218984

Appendix A

Record and Response to Submissions

Extracts from Government agency and authority submissions received in relation to SSD 18_9270, and a response to each of these matters, has been outlined in the table below. It is noted that no submissions were received from the general public.

Stage 2 SSD DA North Tower footprint

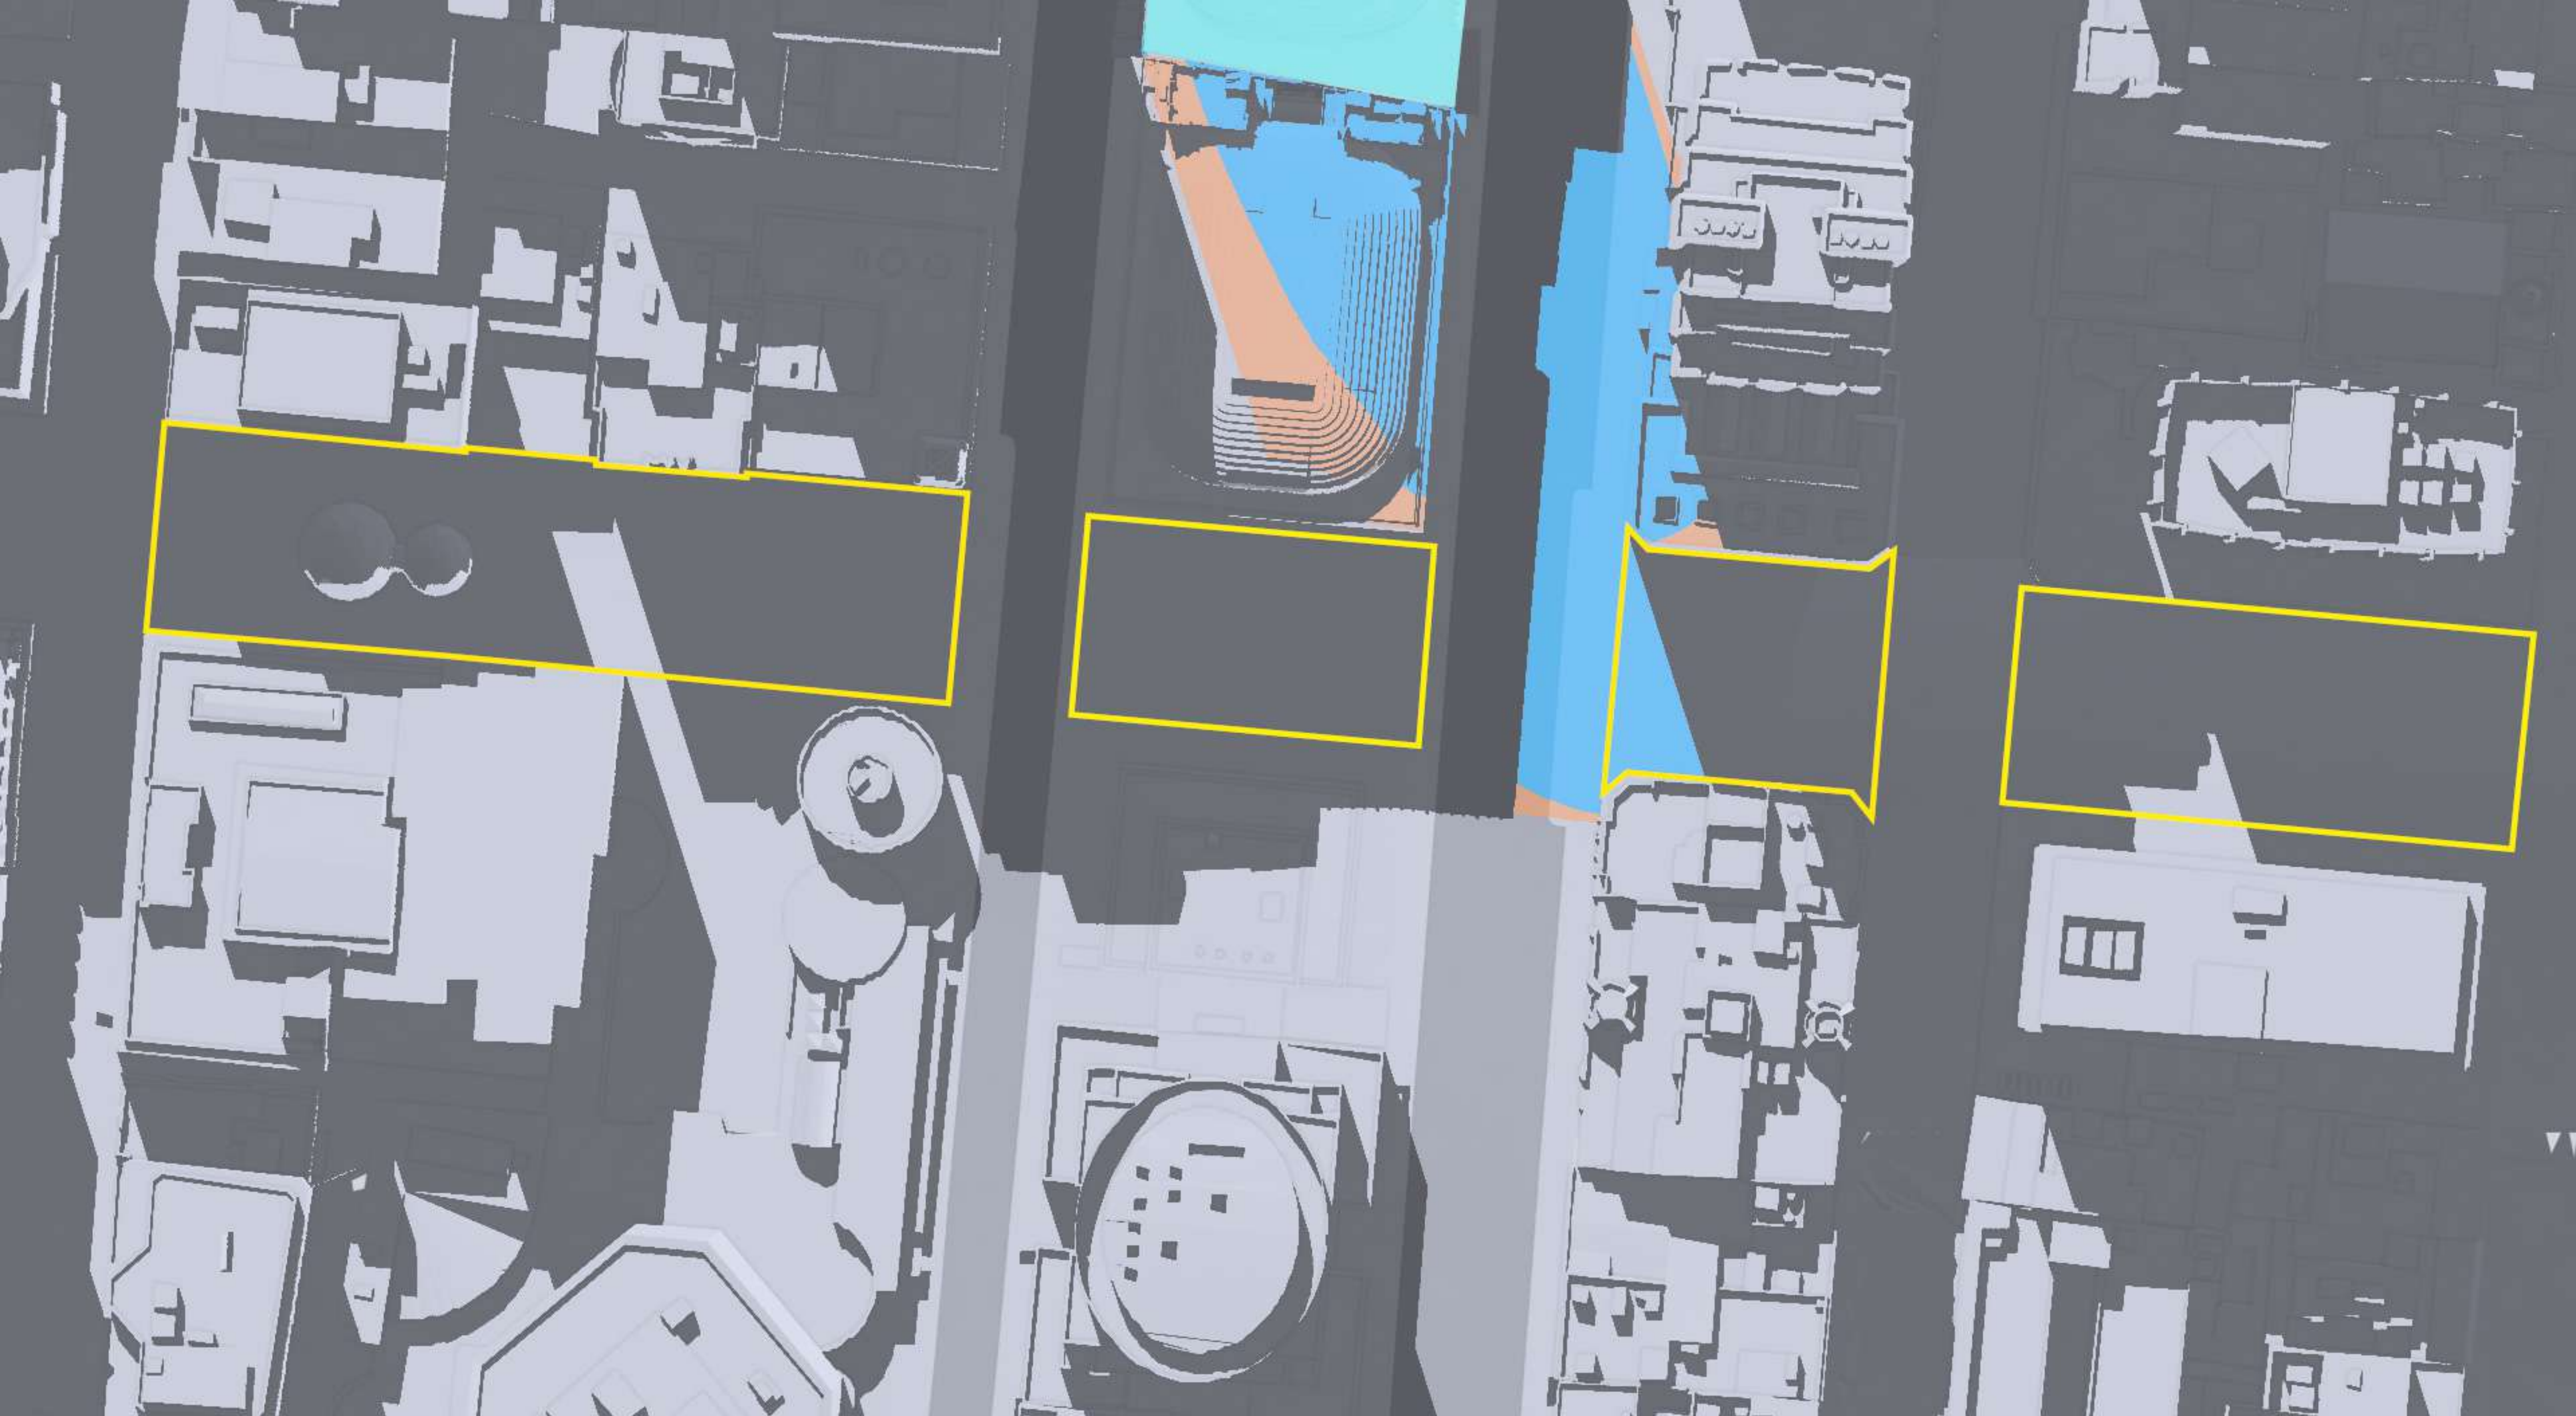
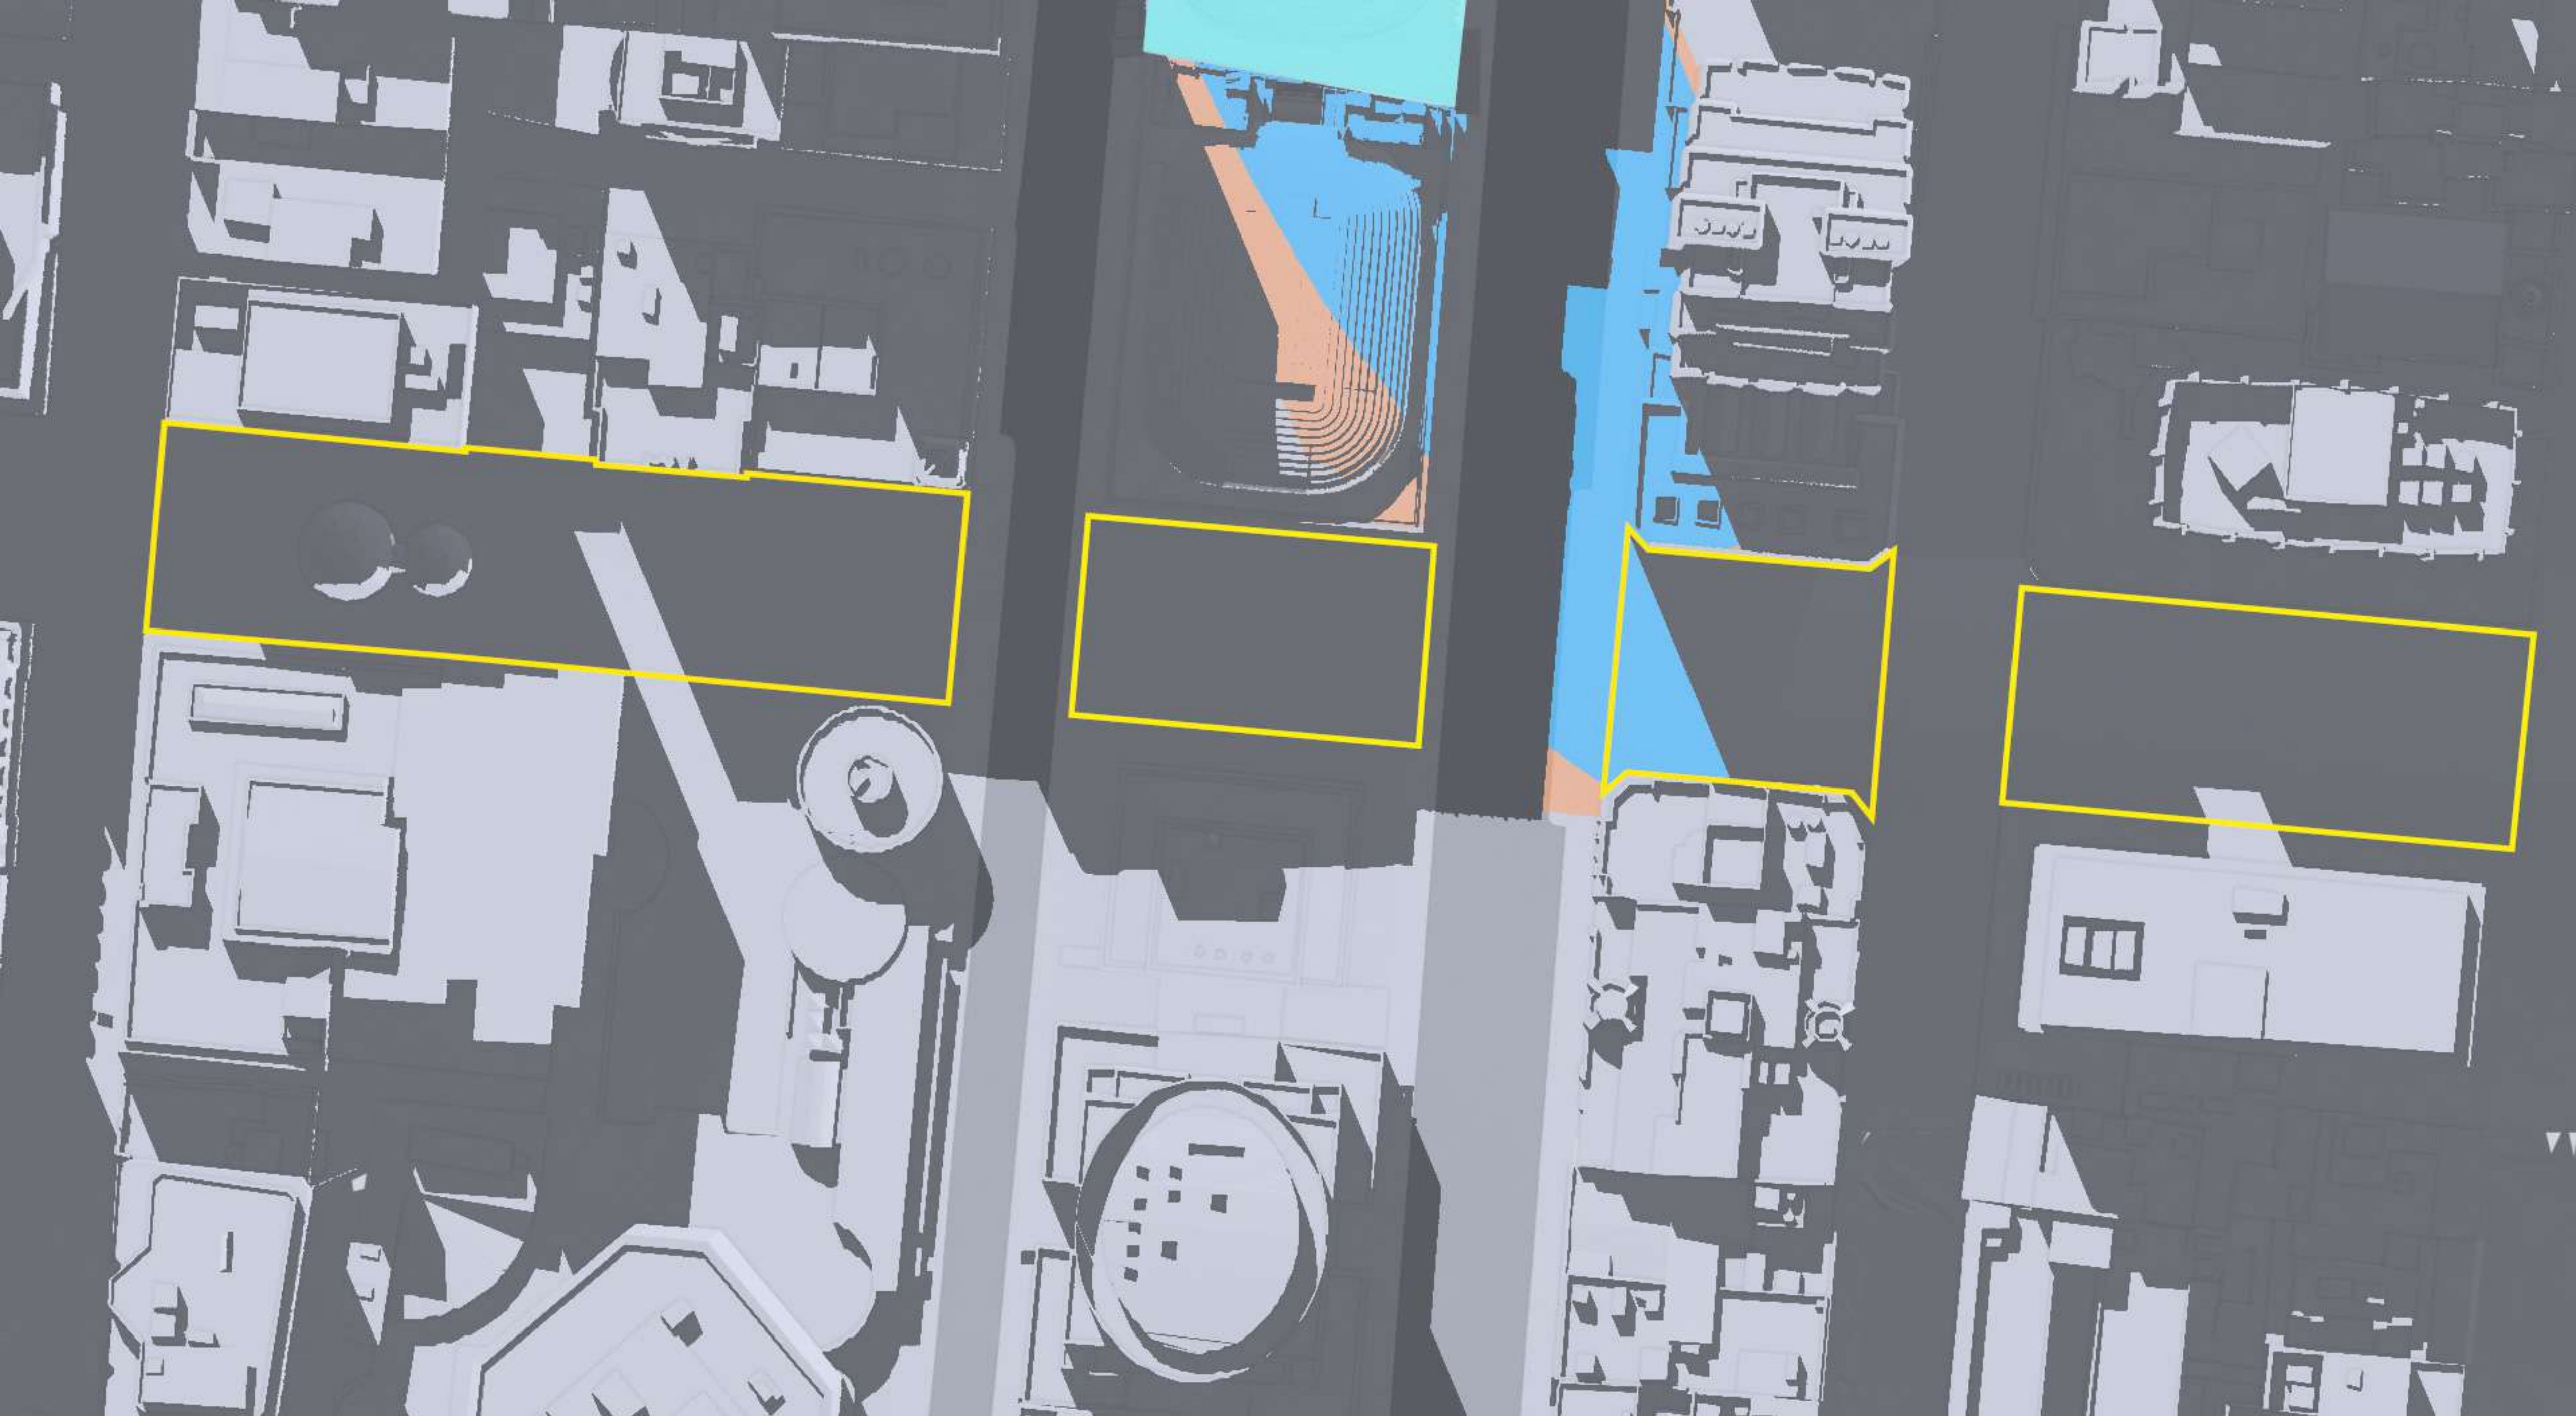
Extract	Response
<p><i>In particular a setback above the podium is essential for Elizabeth Street frontage to address overshadowing of Martin Place which is avoidable.</i></p>	<p>The detailed built form of the North Tower has been the subject of ongoing assessment and development, which has demonstrated that the imposition of tower setbacks will not significantly improve the amenity of public areas surrounding the site. As is discussed in detail in Section 2.1.3 of the RTS, the provision of setbacks above the podium will not significantly improve environmental impacts to the amenity of the surrounding streets in terms of wind, skyview, and overshadowing.</p> <p>When considering the overshadowing impact of the proposal, the overall shadows cast by the proposed detailed design provide 299m² of additional solar access to the ground plane of Martin Place when compared to shadows cast by the approved building envelope. The additional solar access to Martin Place equates to 18% more additional direct sunlight between 12pm and 2pm on 14 April when compared to the approved building envelope and therefore meets the requirements of Condition B2(b).</p>
